Our ref: DOC22/216041

**Heritage NSW - Aboriginal Cultural Heritage - Environmental Impact Statement – Daroobalgie Solar Farm (SSD-10387)**

Thank you for your referral dated 17 March 2022, inviting comments on the Environmental Impact Statement (EIS) on the above State Significant Development (SSD) proposal, with respect to Aboriginal cultural heritage. Heritage NSW has reviewed *Daroobalgie Solar Farm Project - Aboriginal Cultural Heritage Assessment Report, Report to Pacific Hydro, Umwelt Environmental and Social Consultants, June 2021*, and makes the following comments.

FIGURE 6.1A

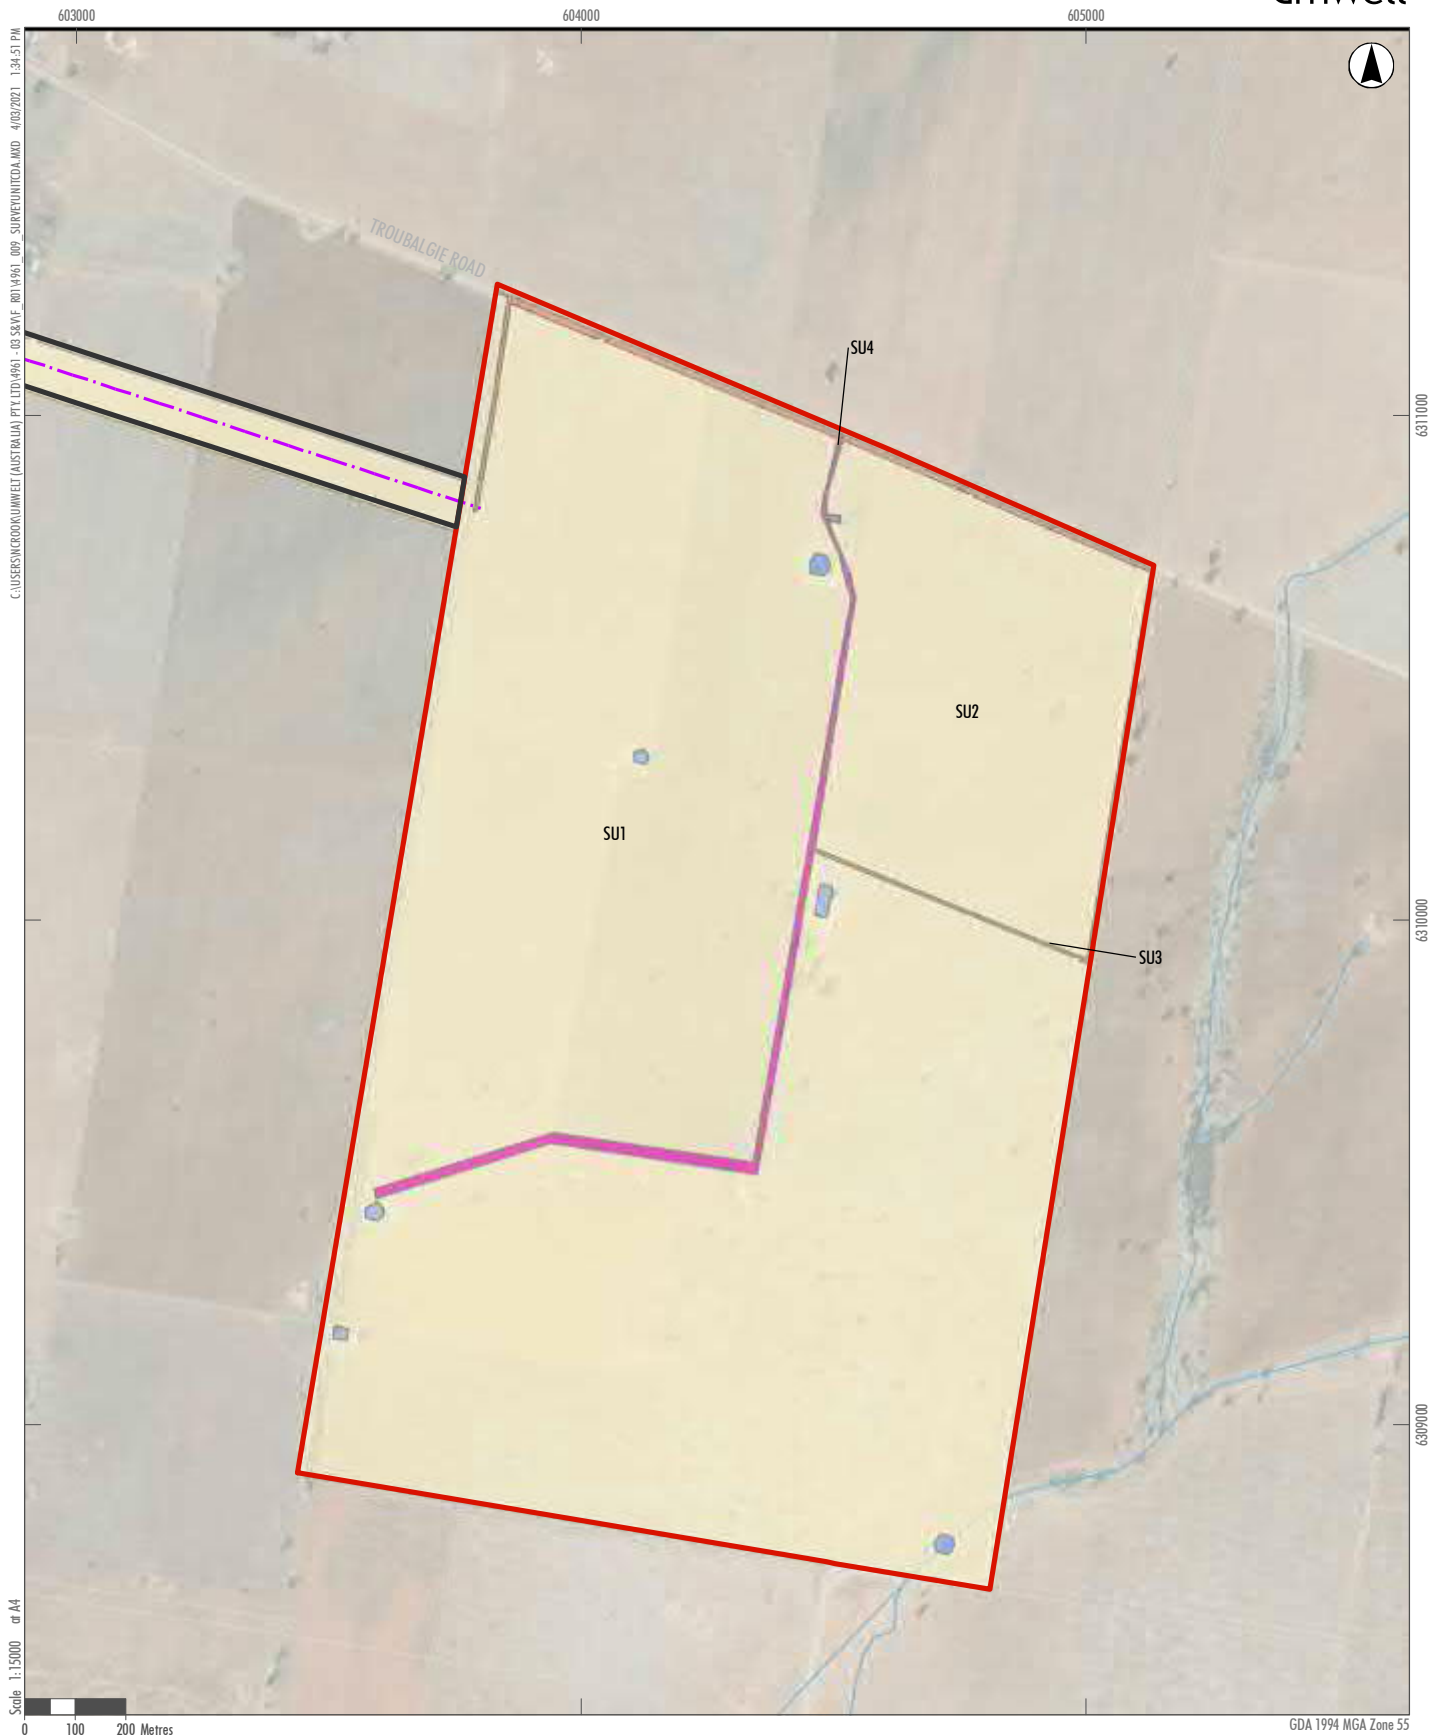
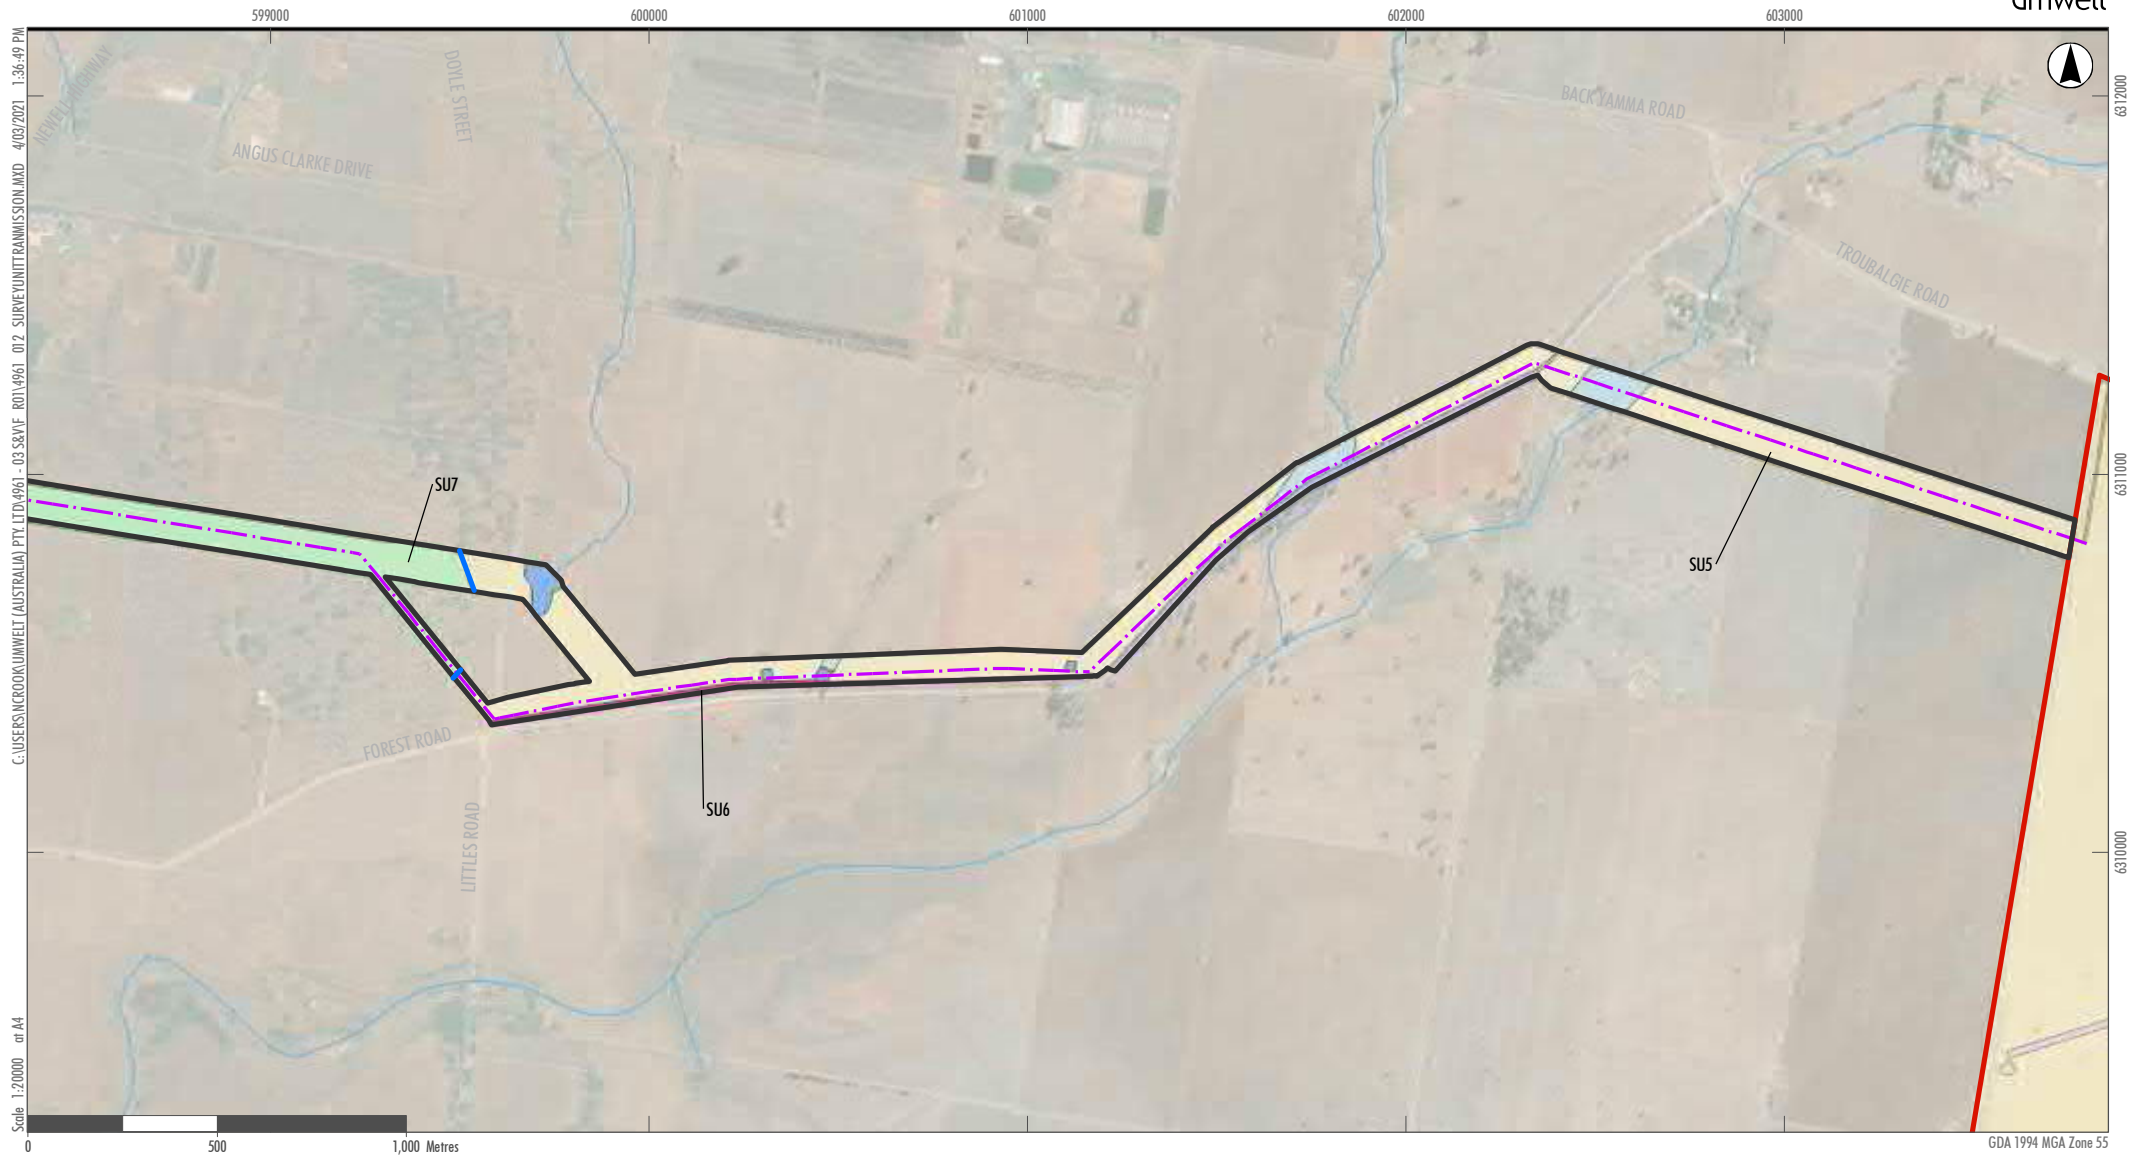
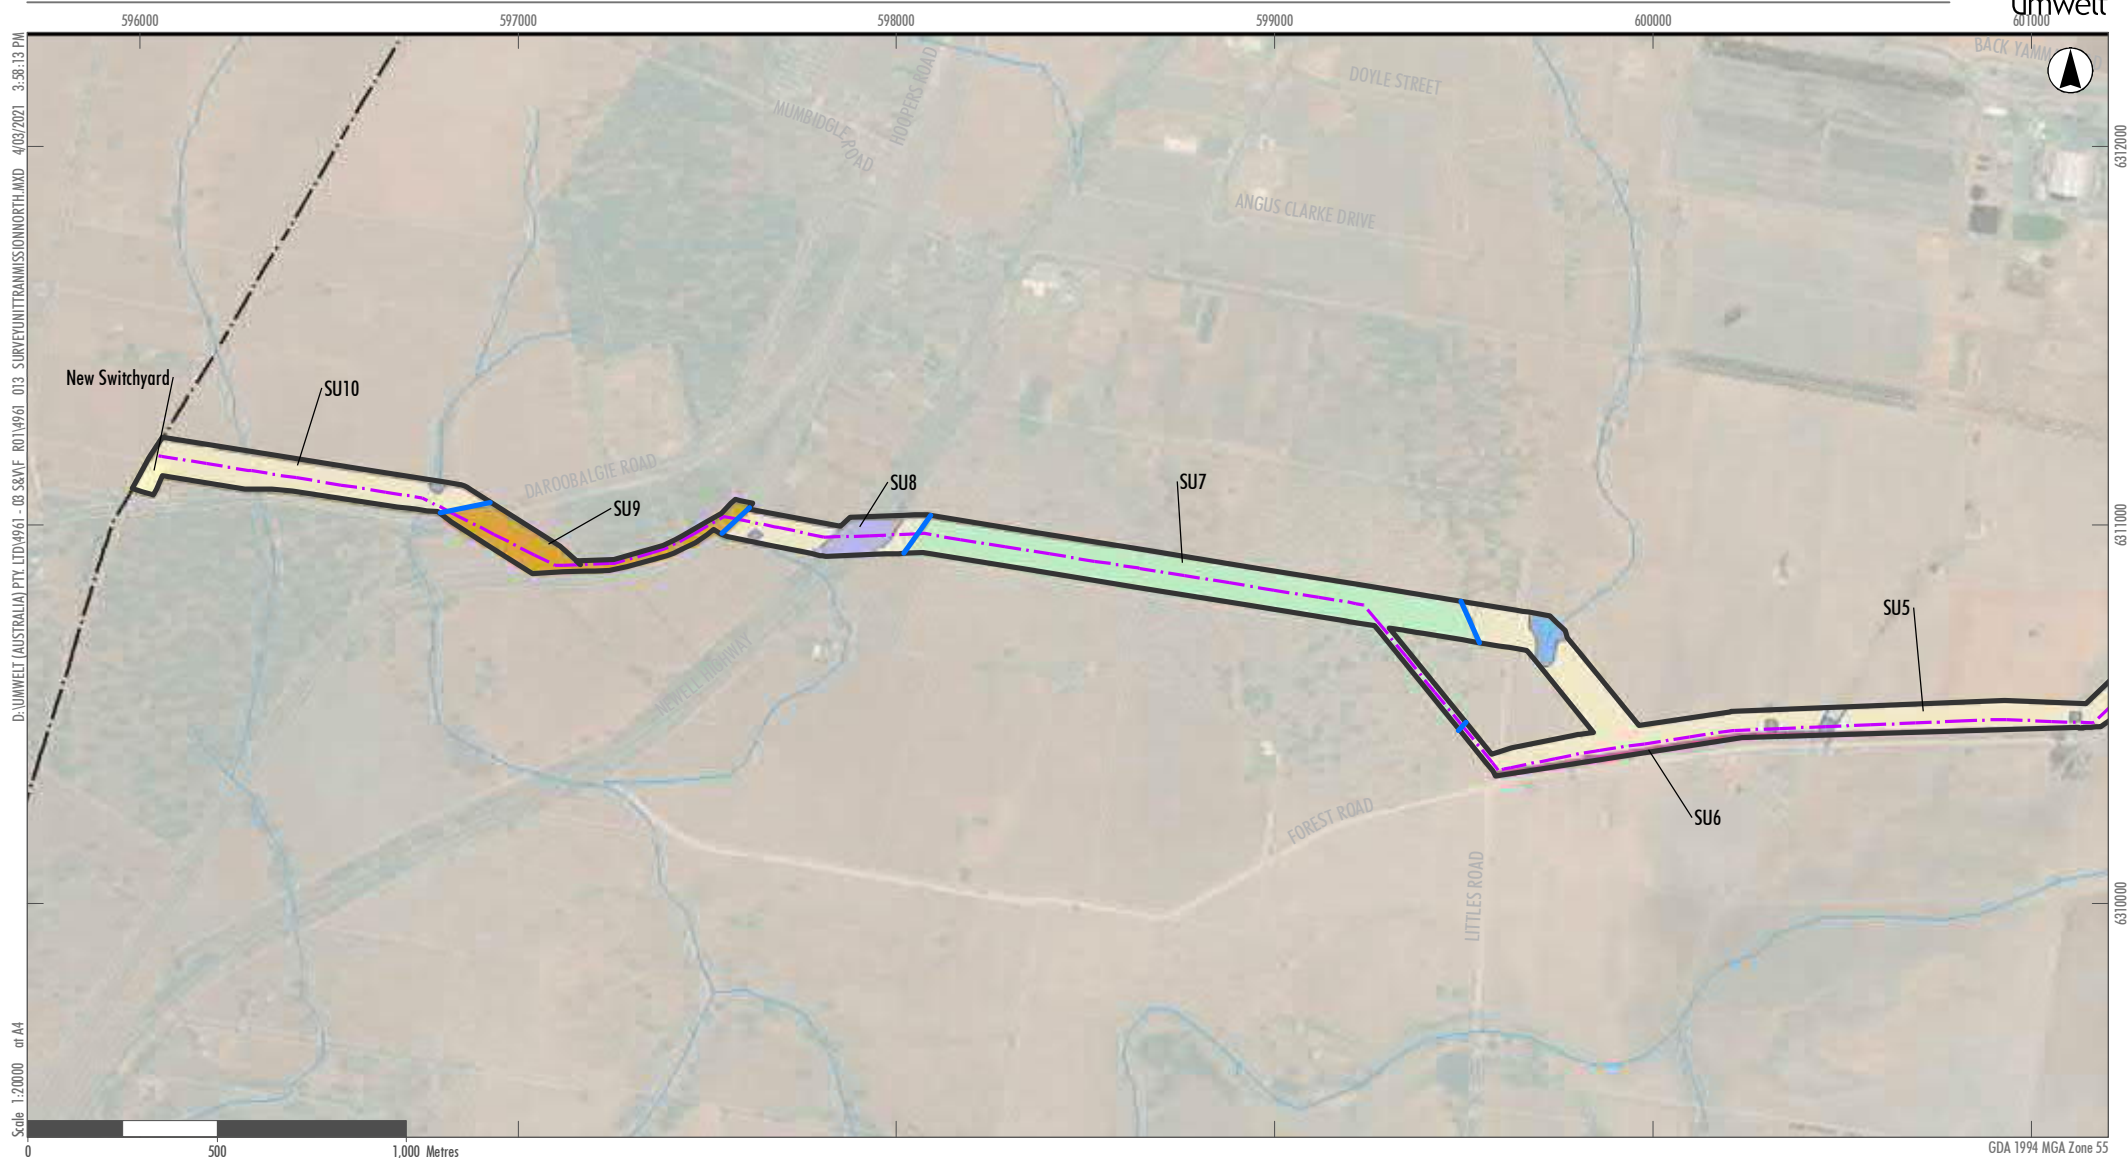
- Heritage NSW requires the track logs and/or location of transects surveyed in order to make an assessment of the thoroughness of the archaeological survey. It is not clear from the provided mapping the extent of survey units, landforms surveyed, and the areas within the units subject to survey.
